Agency Review Comments

Project Name
North Bay at Lake Woodmoor PUD

EA Number
EA24135

File Number
PUD252

PUD DEVELOPMENT PLAN
SITE PLAN

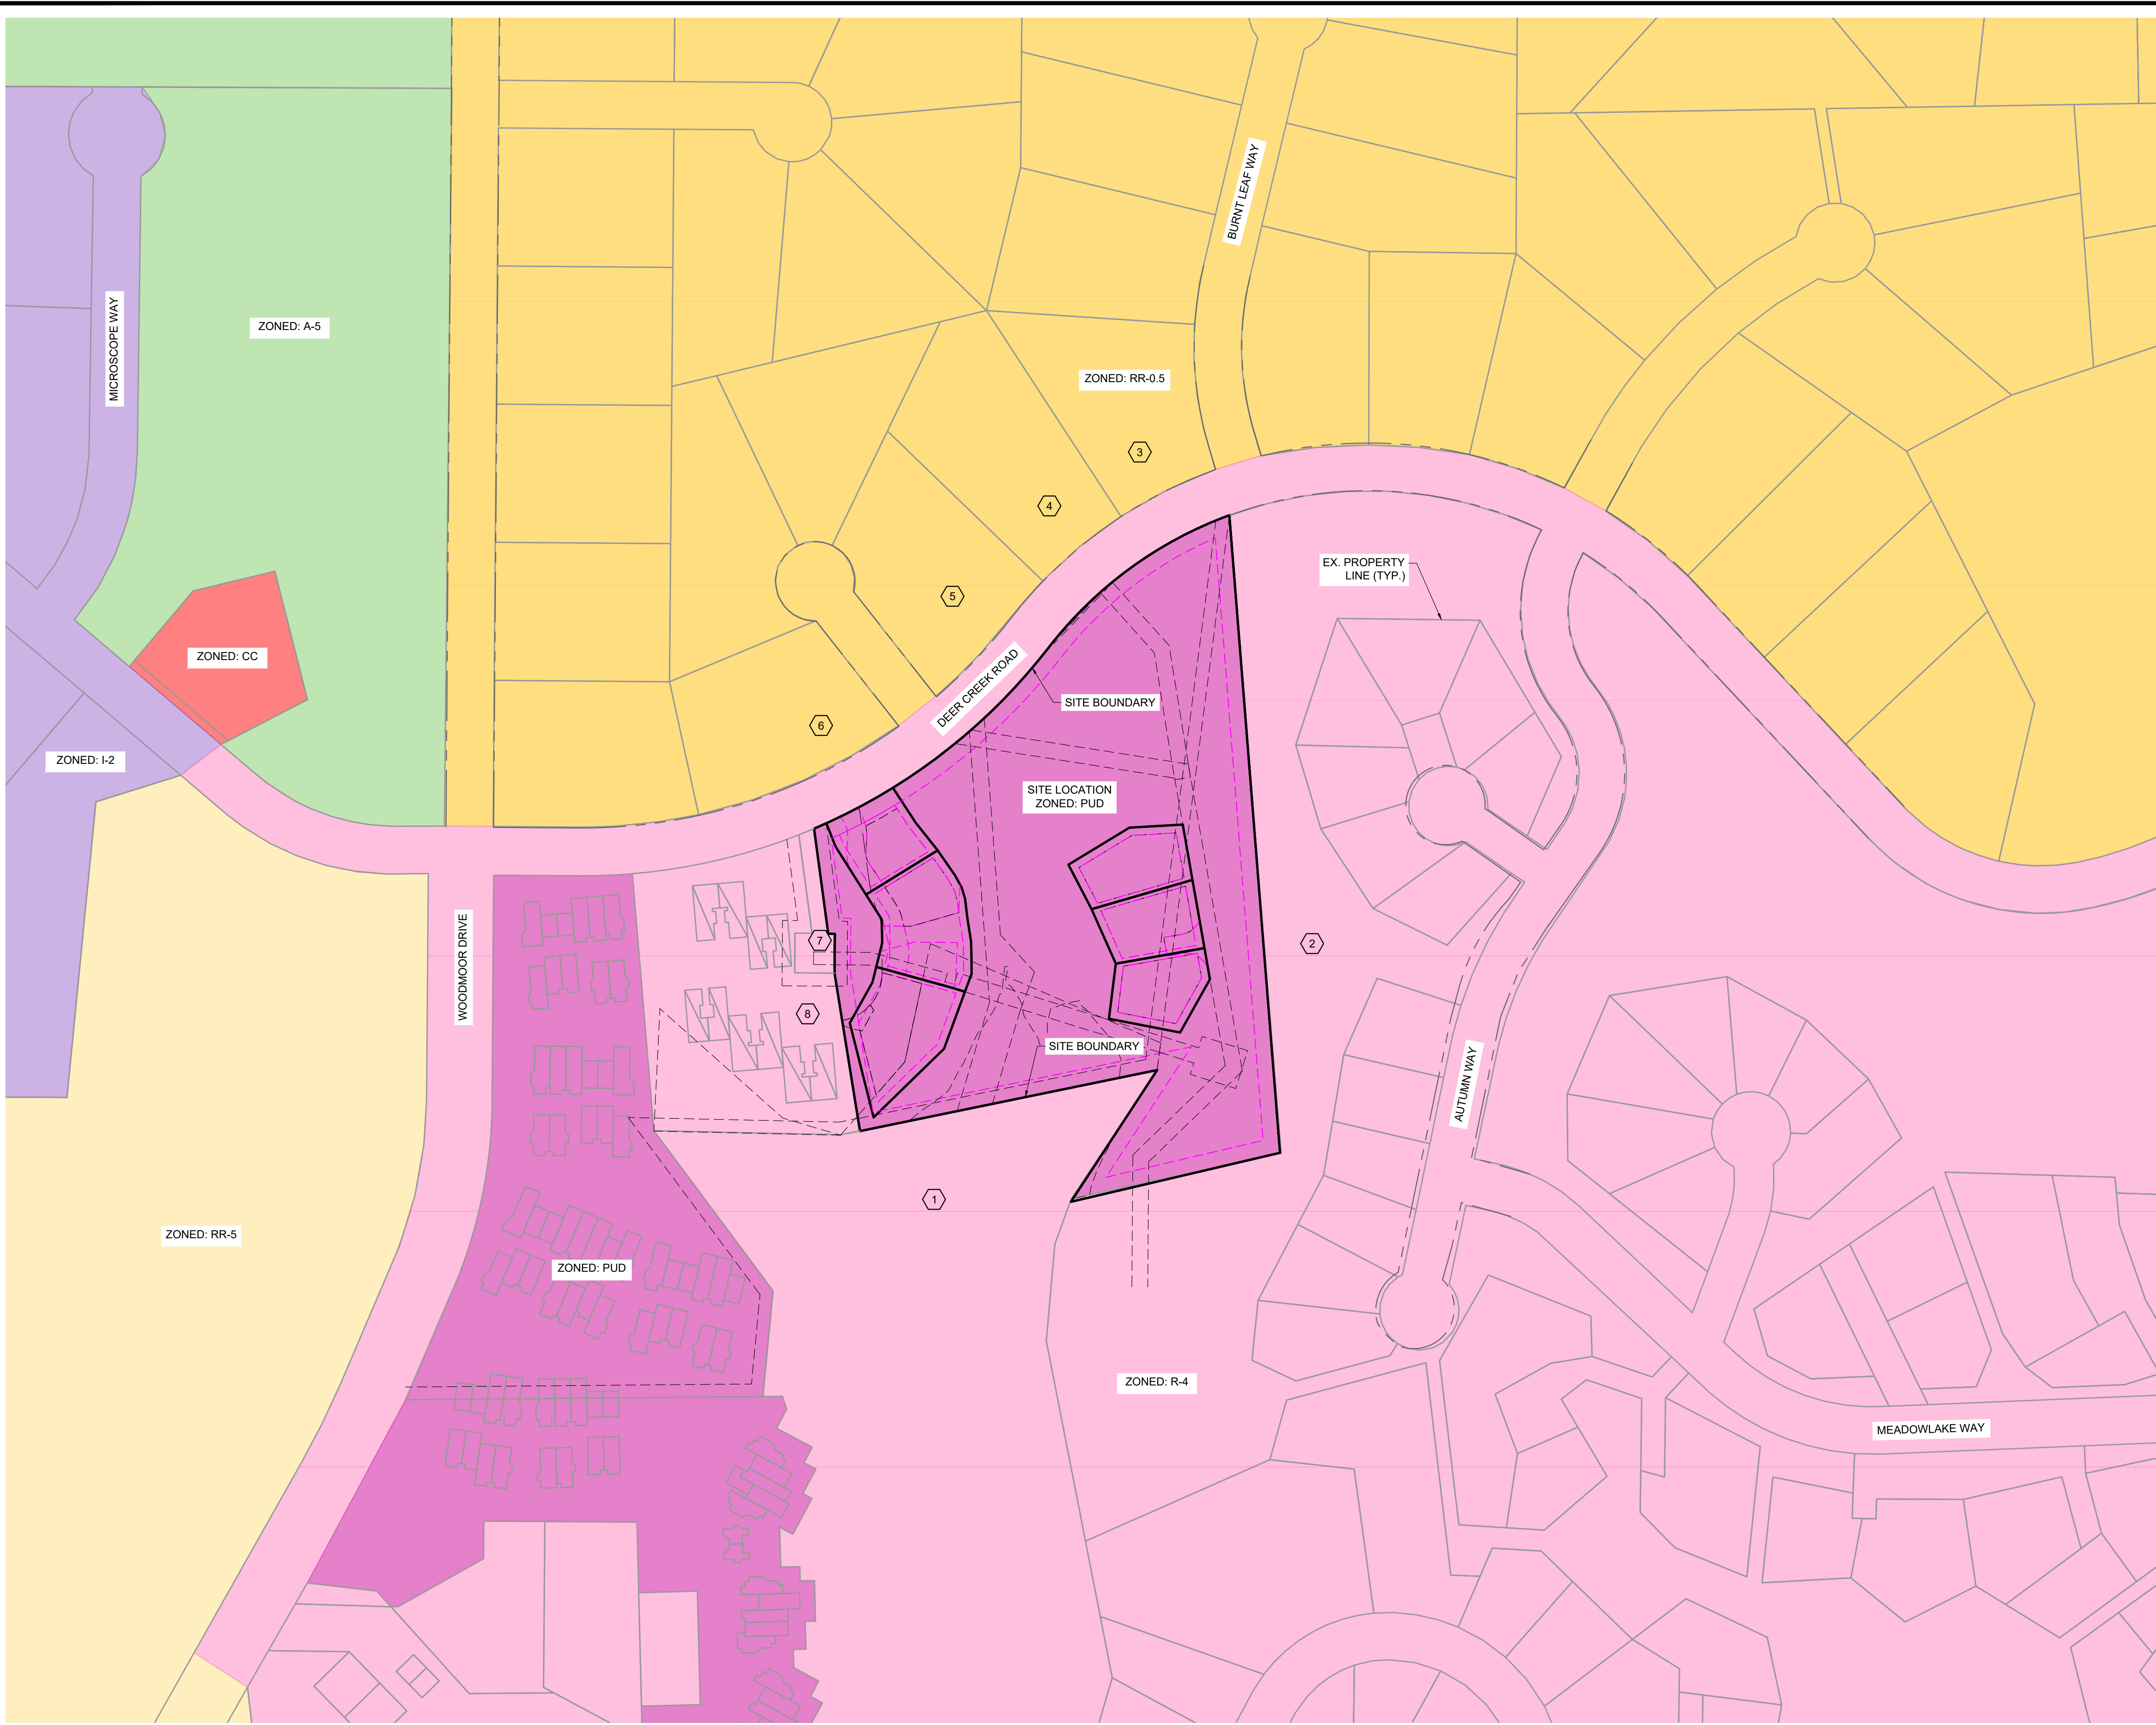
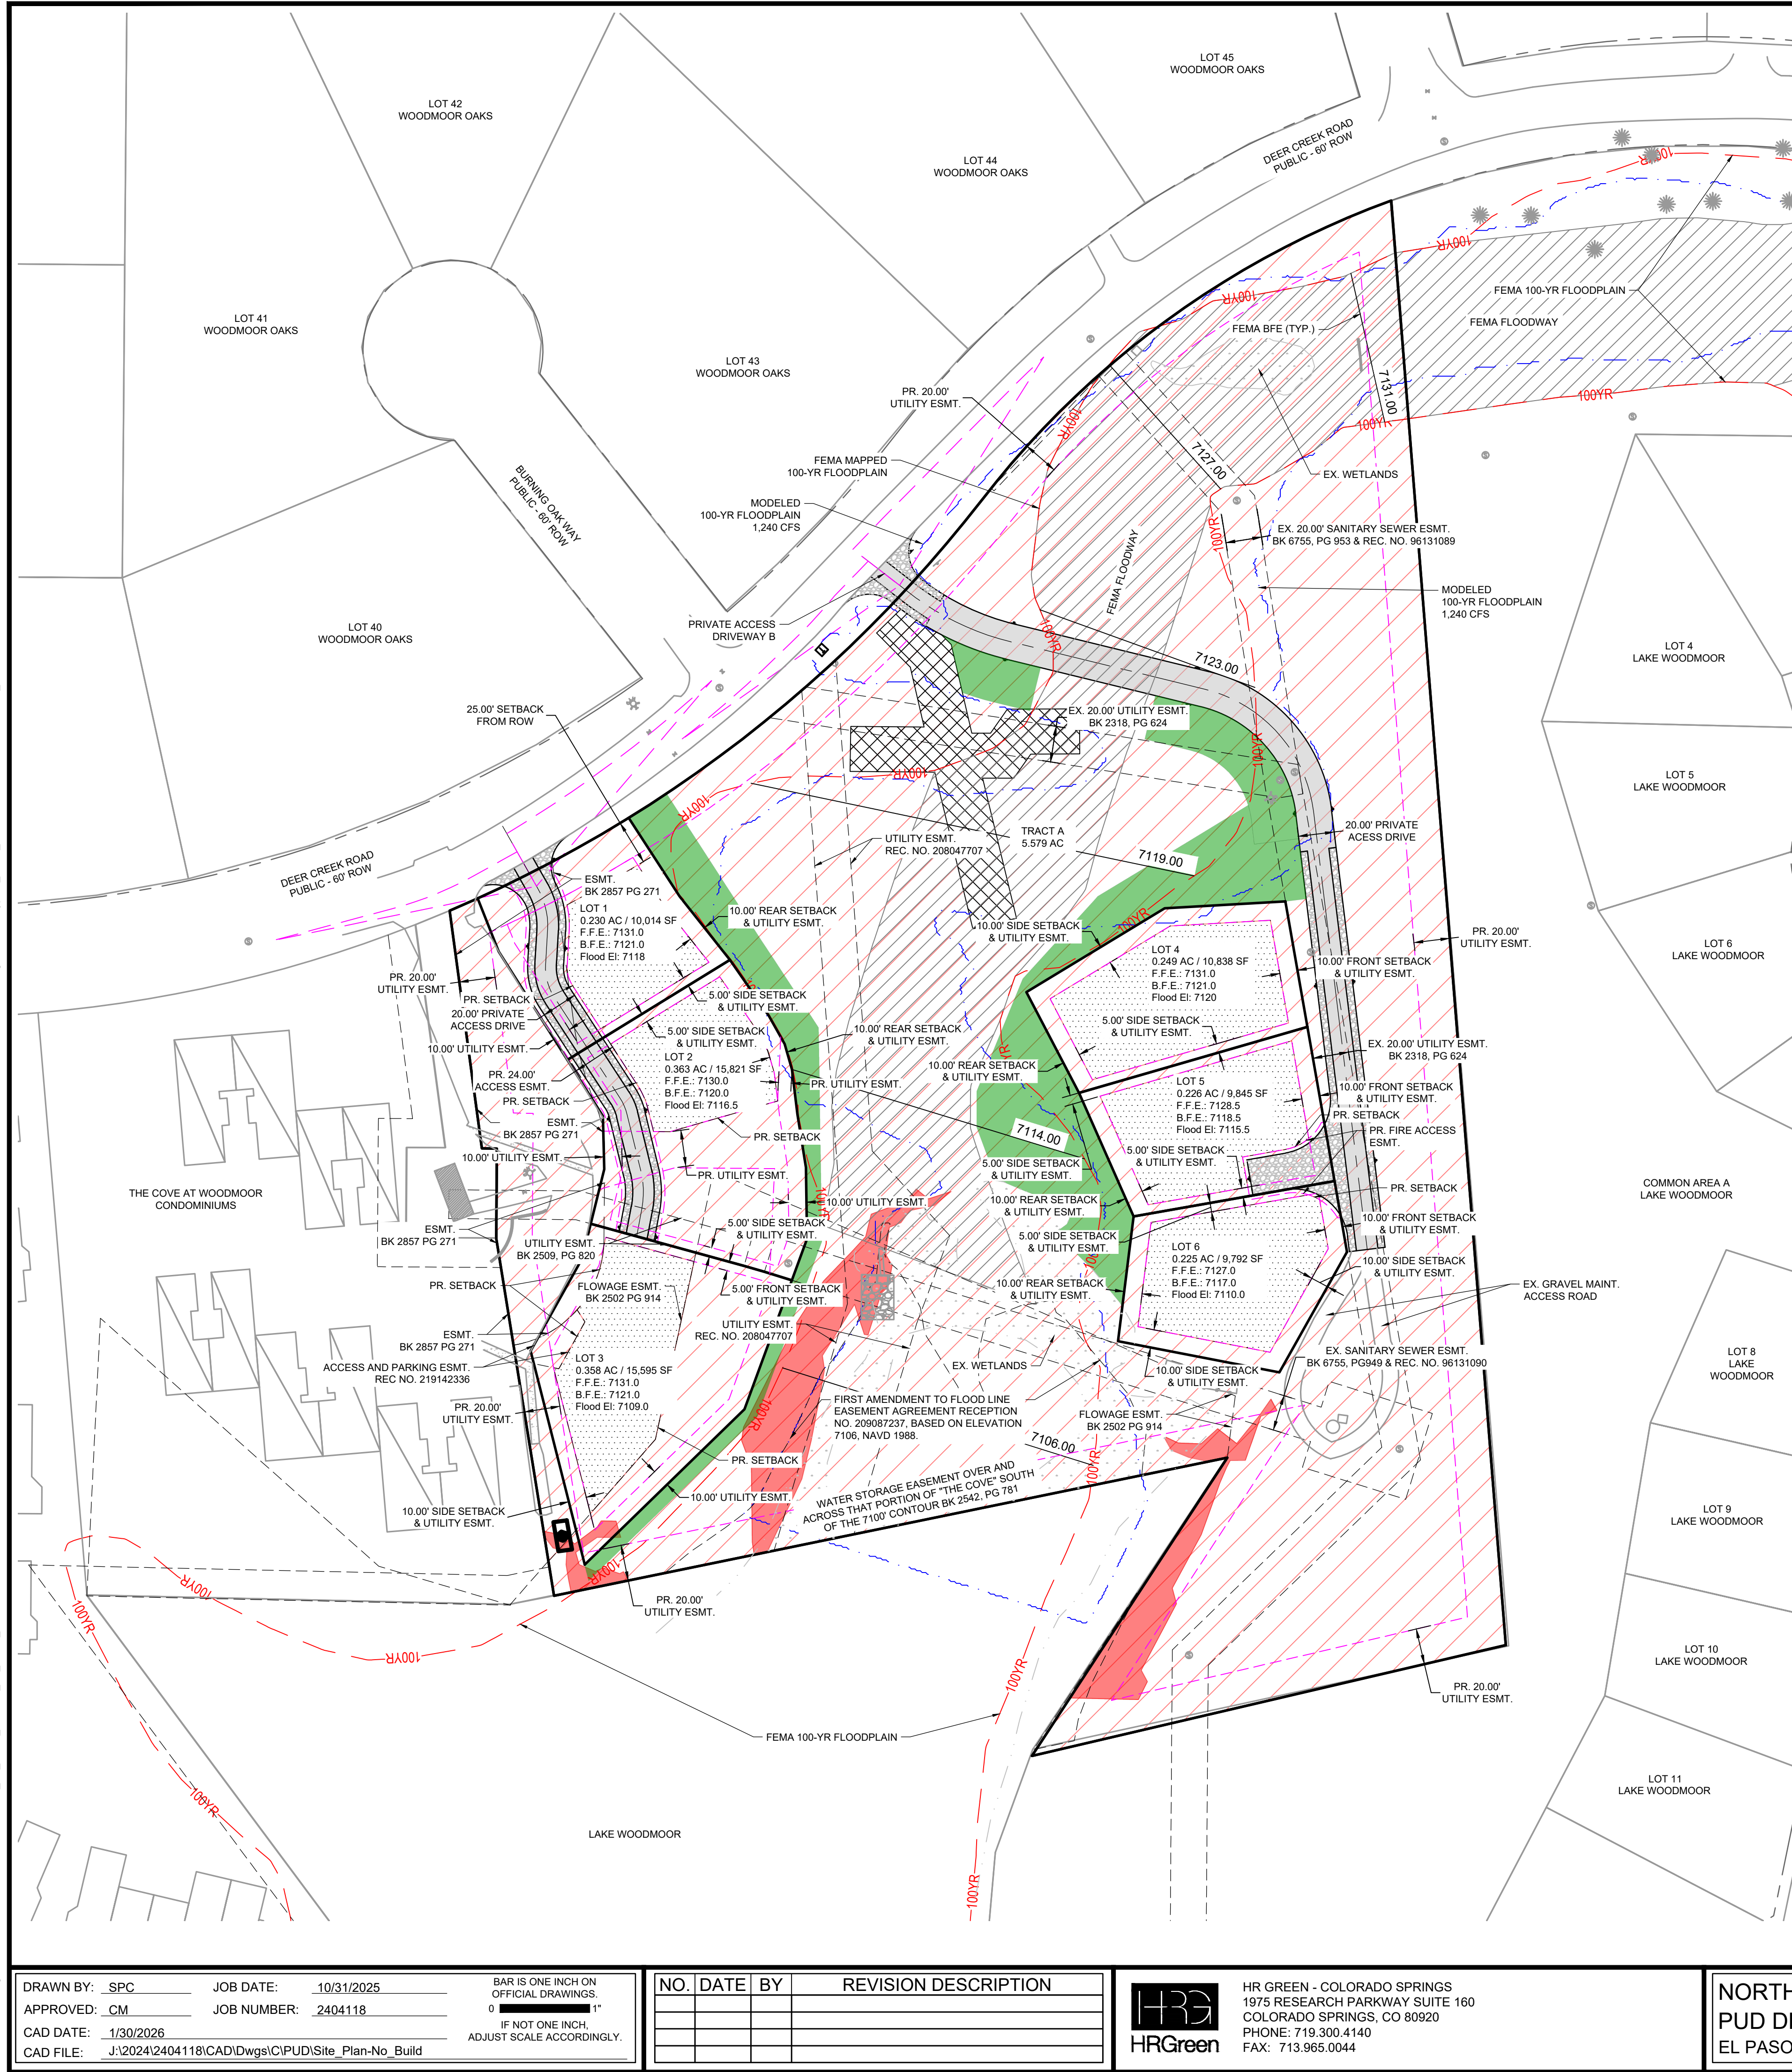
Agency	Review #	Comment	Date
911 Authority - El Paso/Teller County	2	Comments for E911 as follows: The two private access drives indicated on the plan drawings require streetnames. Two streetnames were previously approved for this development (Shoreditch Heights and Redbridge Point). Please ensure that the streetnames are depicted on the plan drawings. Thank you Justin	2/2/2026 11:43:39 AM
RBD Floodplain	2	A floodplain development permit application and zero-rise certification must be submitted to the Pikes Peak Regional Building Department (PPRBD) for any work conducted within the floodplain as part of this project.	2/2/2026 8:12:10 AM
Colorado Division of Water Resources	1	Submitted with Final Plat application	1/7/2026 2:34:14 PM
Mountain View Electric Association, Inc.	1	Please see attached comment letter.	12/18/2025 2:00:21 PM
PCD Project Manager	1	V1_Electric Provider Commitment Letter	12/17/2025 8:00:47 AM

Street names have been provided and depicted on plan drawings.
